Preliminary Acceptance Punchlist
El Paso County – Department of Public Works - Stormwater Section

Project Name:	Retreat at TimberRidge F2
EDARP Filing Number(s):	SF2121 CON2229
ESQCP Number:	ESQ2224
Attendees:	DPW SW: Ben Jones, Glenn Reese, Mikayla Hartford, Dylan Finley DPW Dev Services: David Parkerson Developer: Adam Doyle
Date of Walk-Thru:	05/23/2023
Walk-Thru Number:	1

DETENTION FACILITY POND 3
POND PLAN

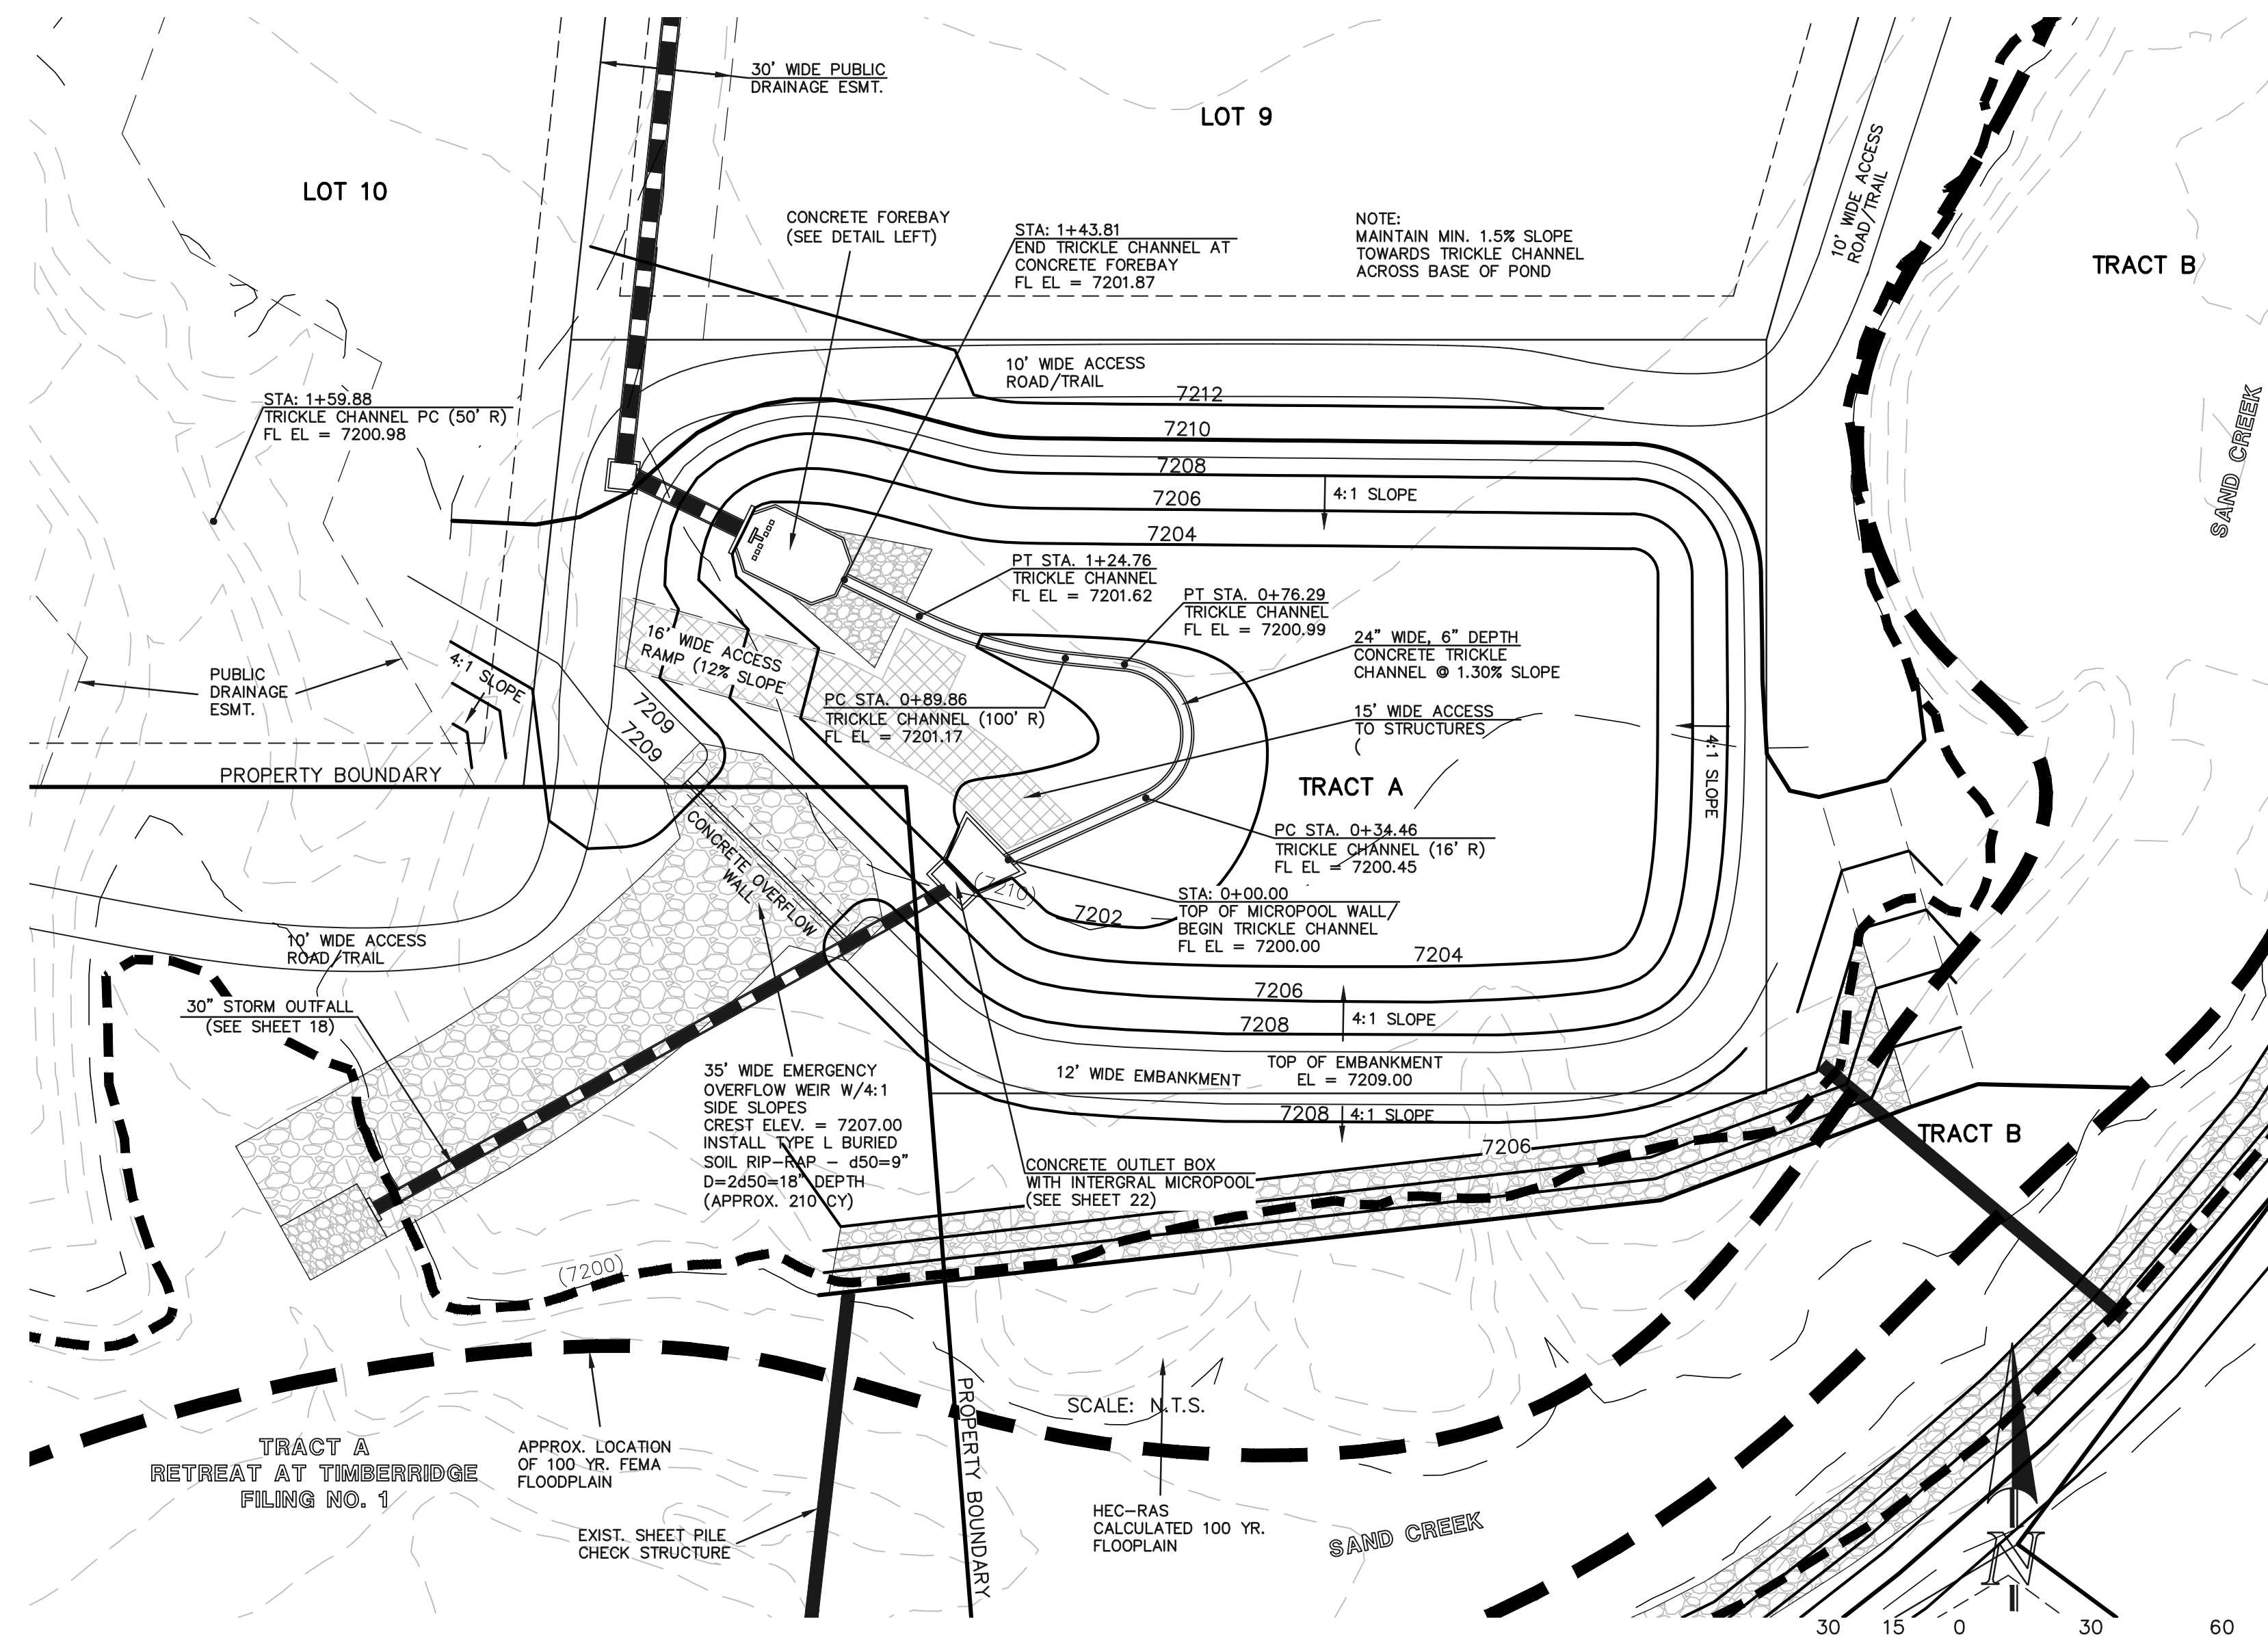
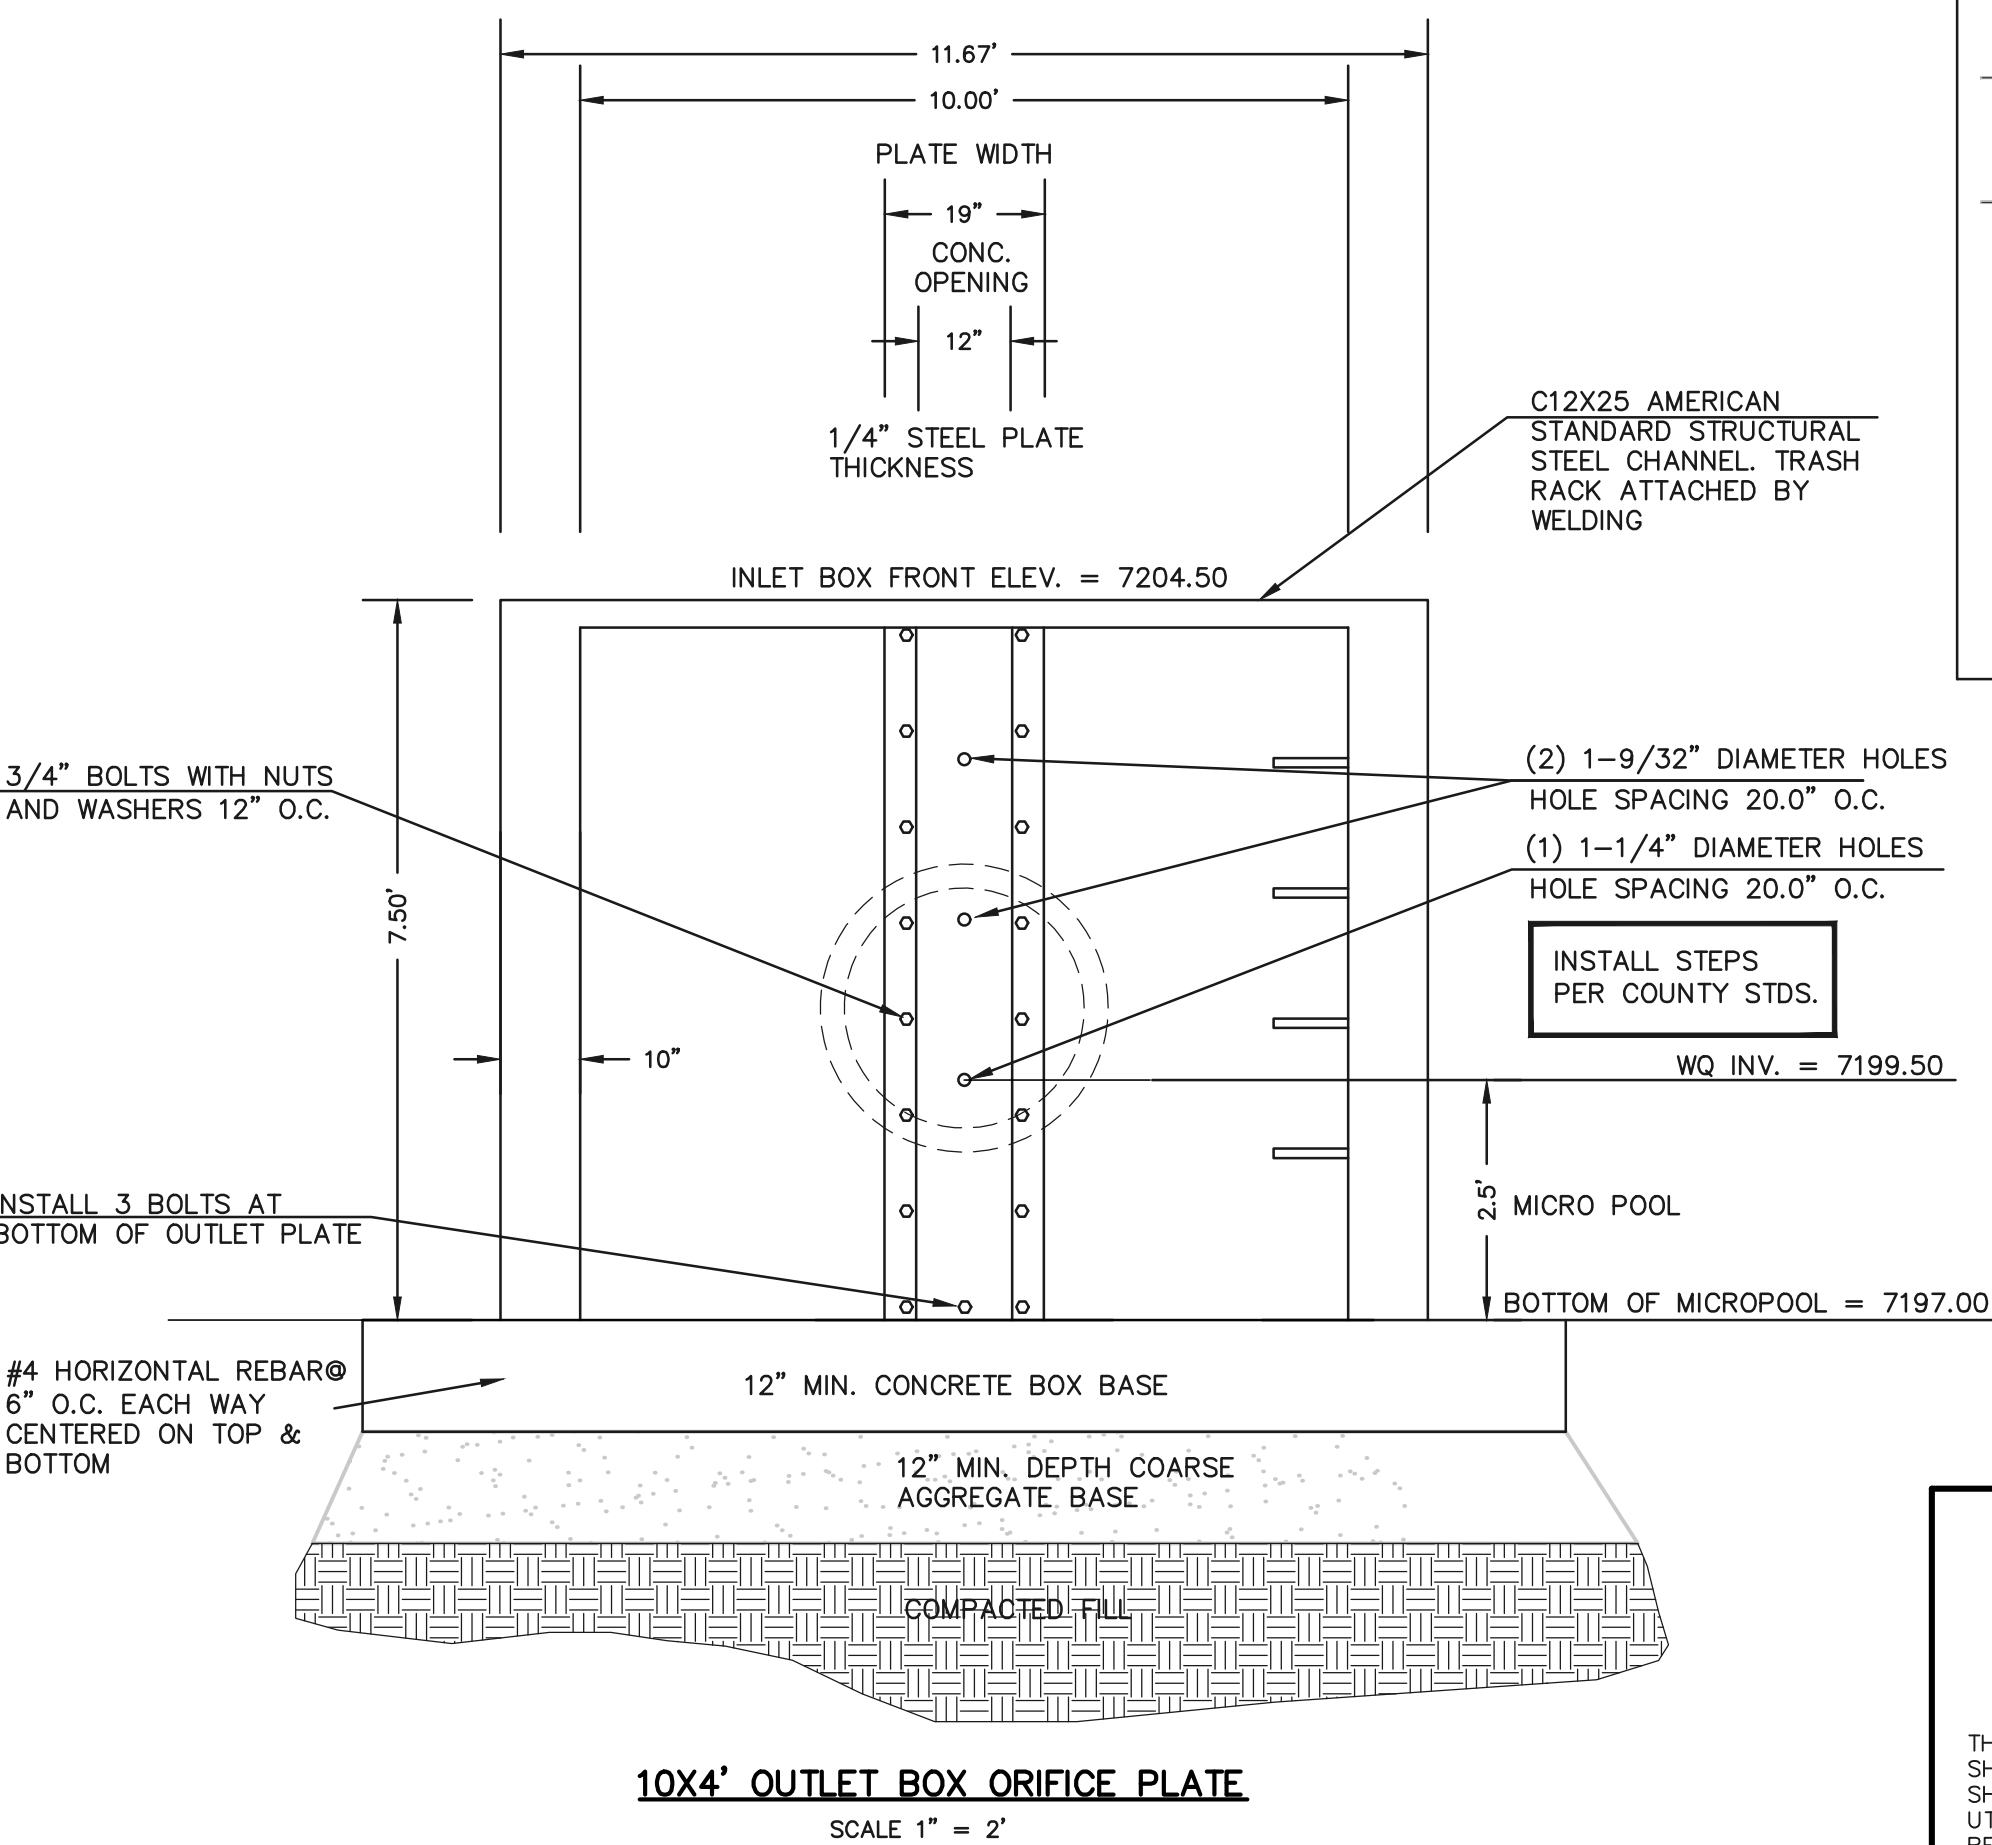
- Soil riprap around forebay not installed per specification. Photos 9 and 10
- Re-grade pond bottom to top of trickle channel curb with a 3% slope towards trickle channel for positive drainage.
 - Pond appears to have insufficient capacity with higher elevations between trickle channel and access road than what is shown on plans. We will verify this on as-builts.
- Erosion/undercutting around inlet pipe
- Soil riprap at pond spillway not installed per plan. Soil riprap needs to be installed to existing grade.
- Erosion at northeast corner of pond embankment.
- Maintenance access road not installed per plans. Does not extend to outlet structure.

Photo 8: Soil riprap at pond spillway not installed per plan. Soil riprap needs to be installed to existing grade. (Page 21 of CD's)

Photo 9: Soil riprap around forebay not installed per spec. (Page 21 of CD's)

Photo 10: Soil riprap around forebay not installed per spec. (Page 21 of CD's)
